Address: 52L, Wellhouse Lane, Mirfield, Wf140pw

Application number: 2025/93355	
What is the application for?:	Erection of 75 residential dwellings with associated landscaping, open space, hi
Address of the site or building:	Land off, Woodward Court, Mirfield, WF14 0PY
Postcode:	LS15 8ZB

Type of comment: An objection	
Do you wish your comments to be published on the website anonymously?	No

A Key plan updated.
STREETSCENES - 2520-SS-01A
WOODWARD COURT, MIRFIELD
BELLWAY HOMES
SCALE:1:200@A1 - NOVEMBER 2025

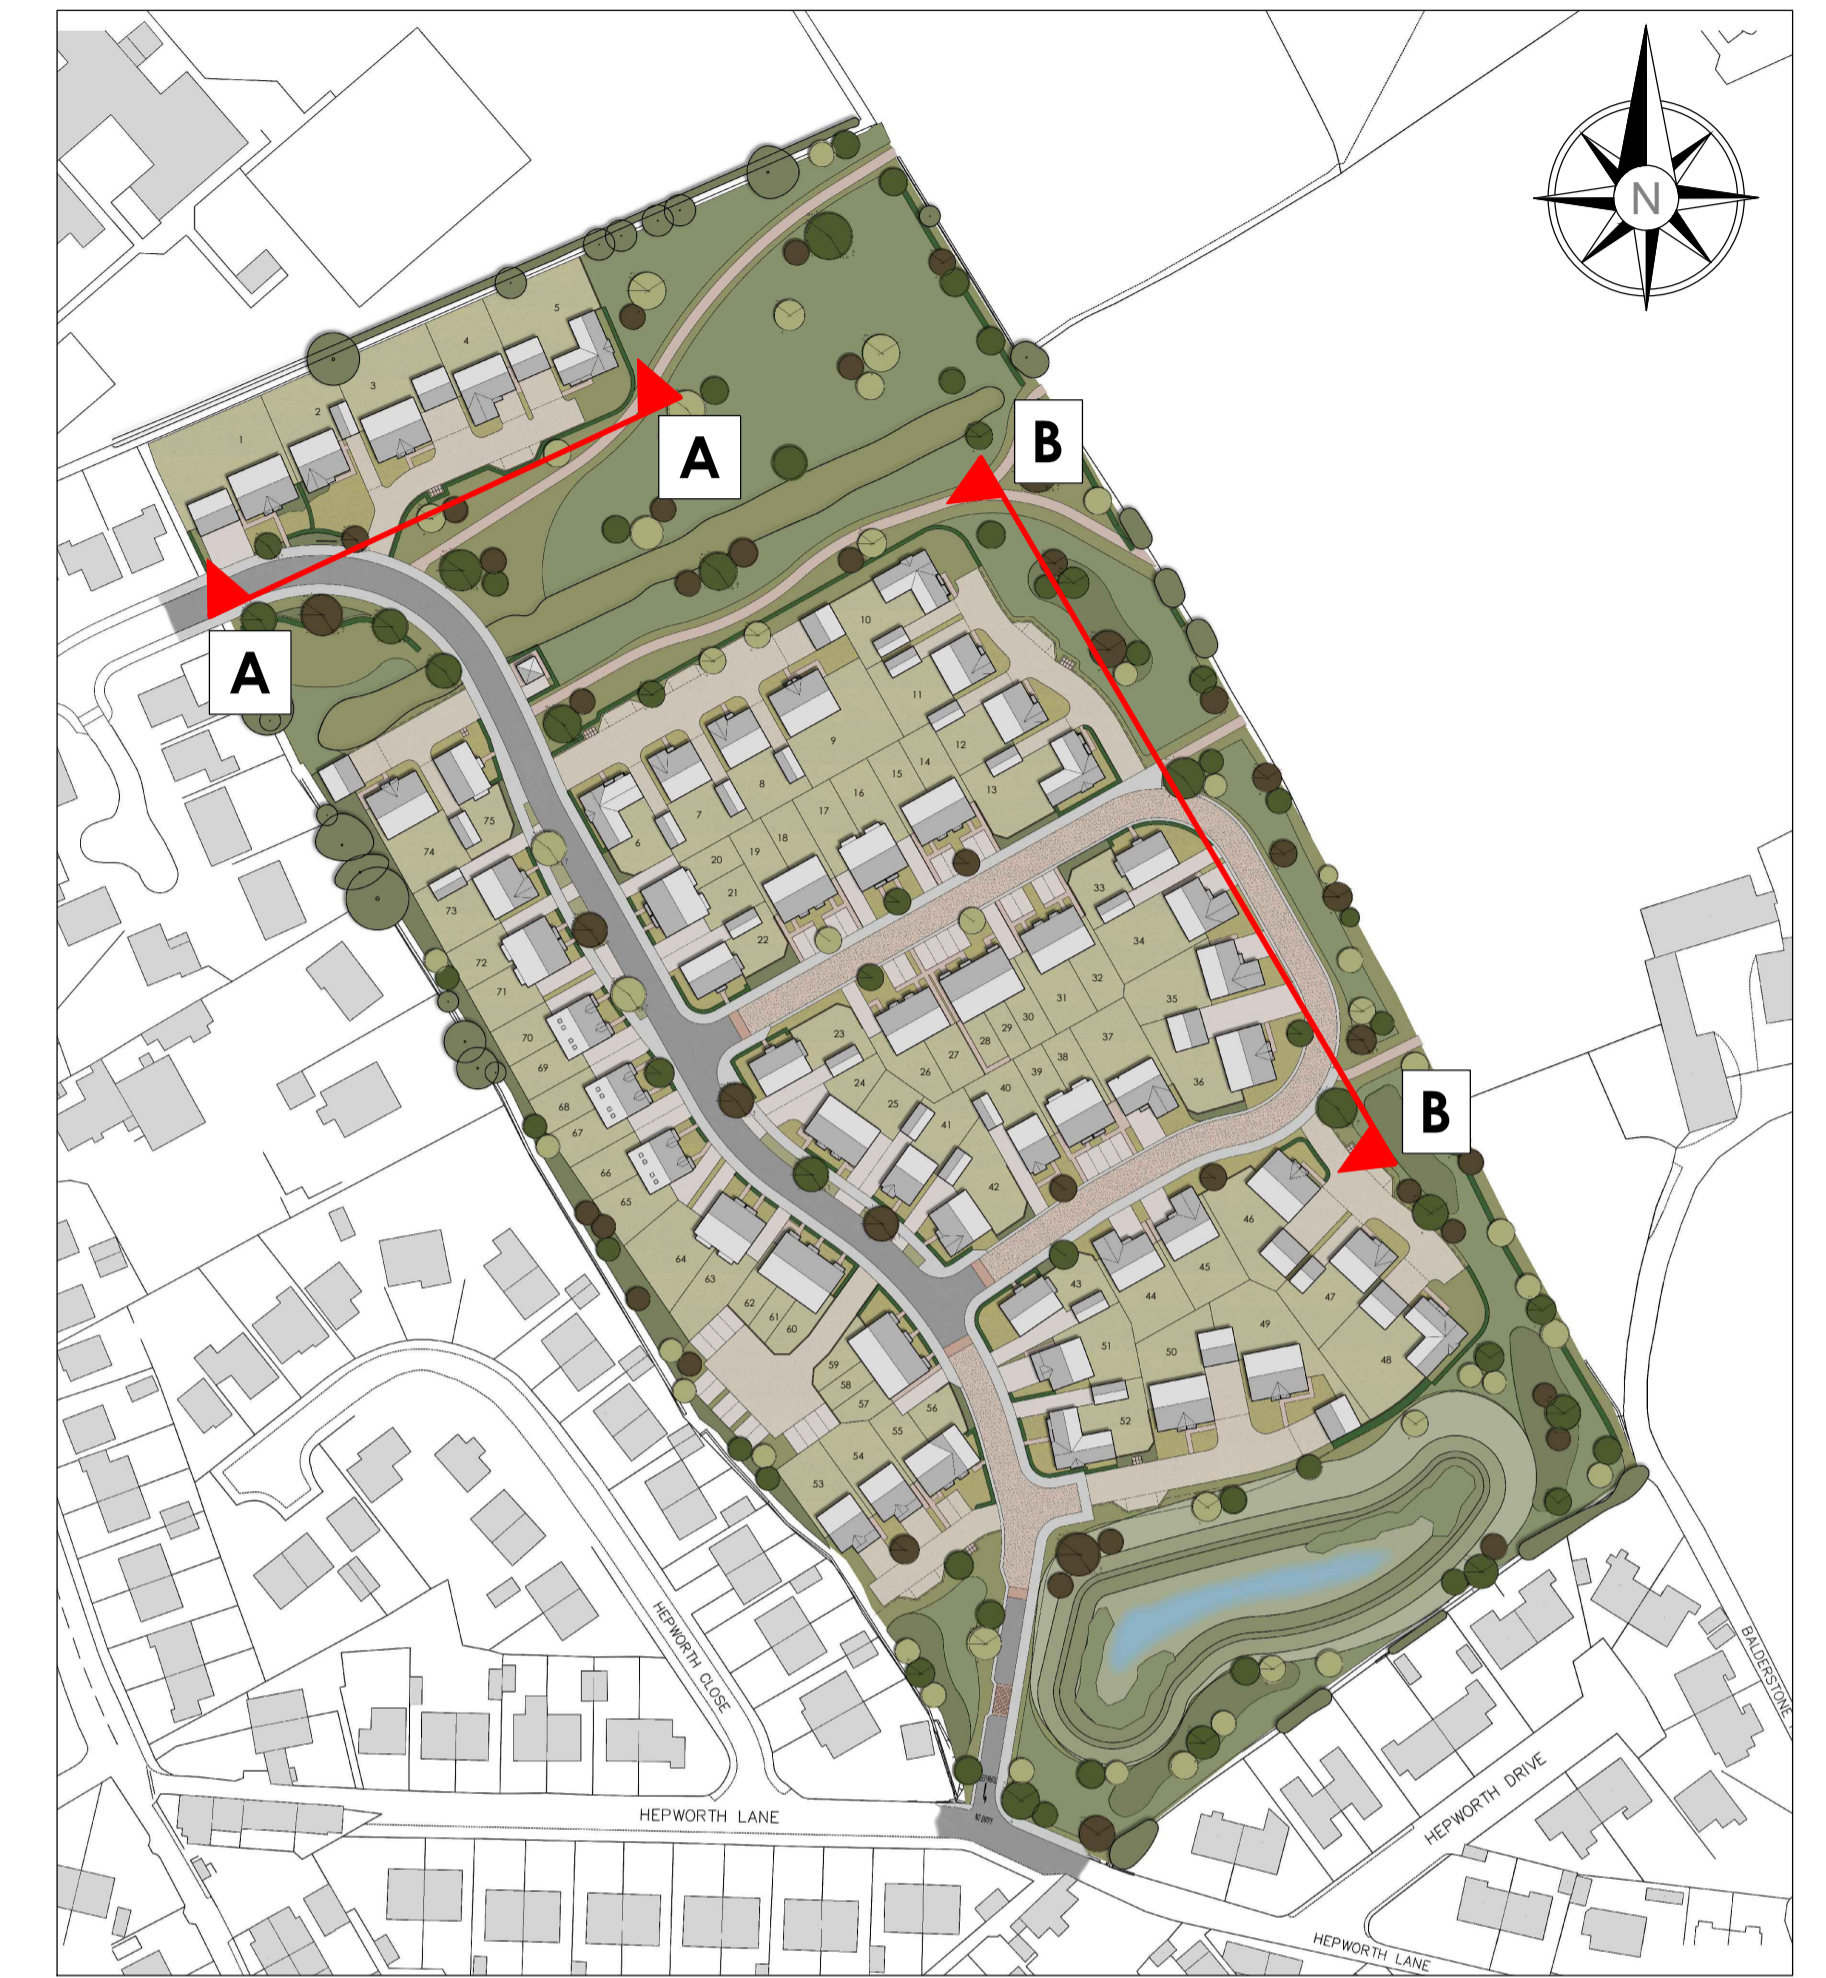
The buildings proposed to be built behind Wellhouse Lane , are of three storeys which make them higher than other buildings in the area and therefore out of character.

These buildings will overlook existing housing resulting in a loss of privacy.

Image 3.4 Proposed Hepworth Lane Site Egress

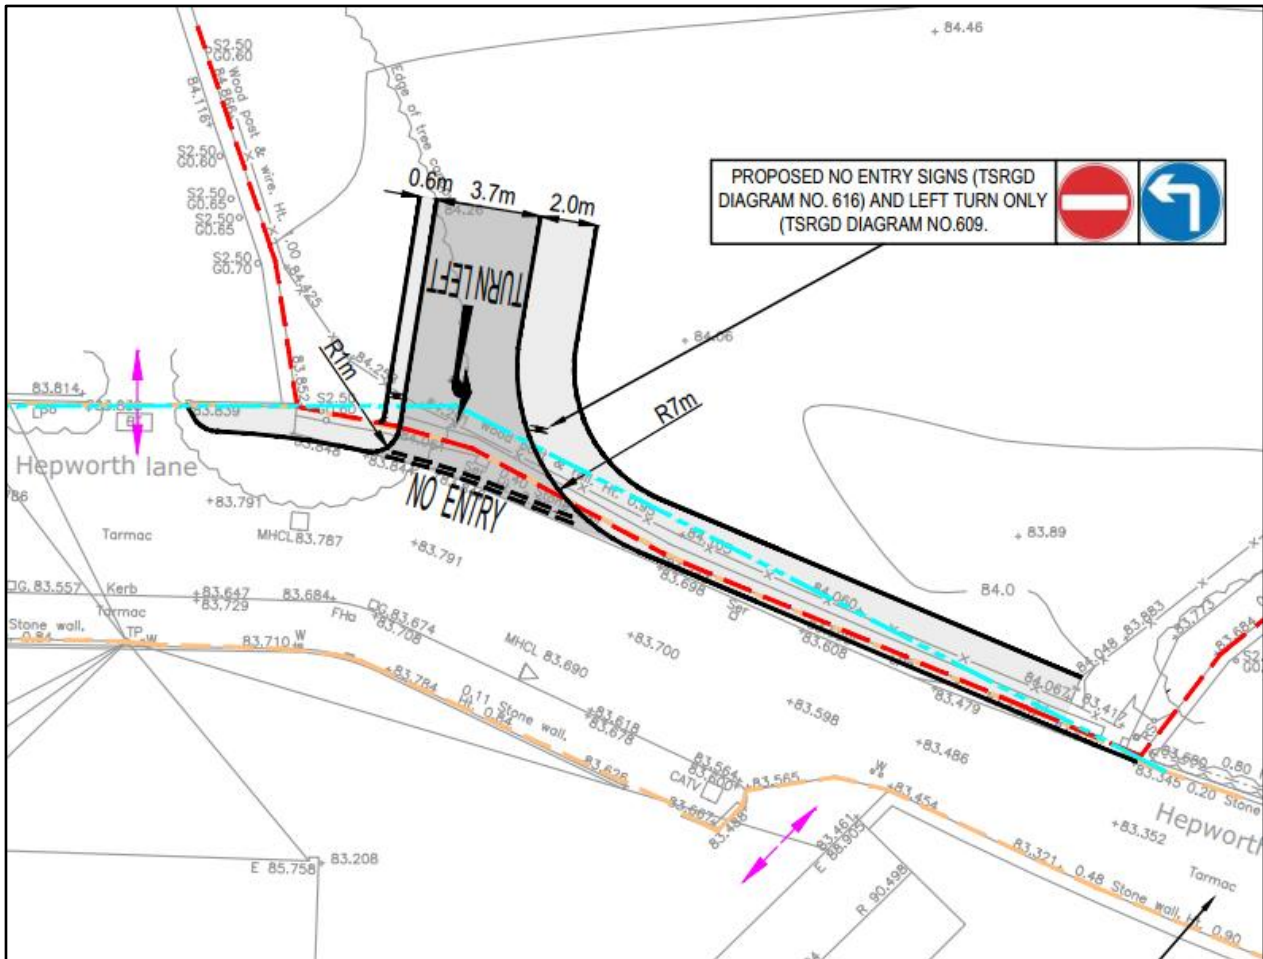
The developers' suggestion to include access to Hepworth Lane would actually make this more dangerous, as sight lines on to this street are inadequate and there is no pavement in places on this very narrow road. Increasing traffic on this road will represent a serious danger to pedestrians and residents.
